DOC19/930217

**Powering Sydney's Future (SSI 8583)  
Advice on the Environmental Impact Statement**

## EPA COMMENTS ON POWERING SYDNEY'S FUTURE

Monday, 20 May 2019

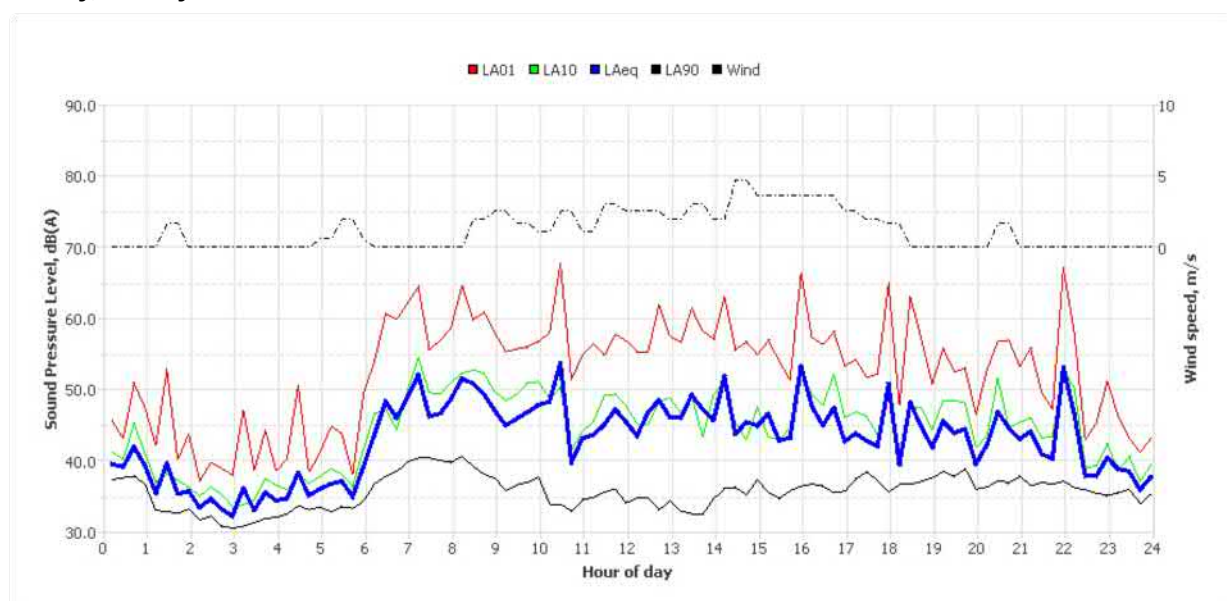
2. There appear to be typographical errors in Table A-4 Unattended noise measurement results in dB(A) – NCA 4. For example, the background noise level (LA90 dB(a)) recorded for Monday 20 May 2019 is '337'. This error is significant as it would (if not corrected) vastly throw out any average calculations for background noise levels in the noise catchment area.
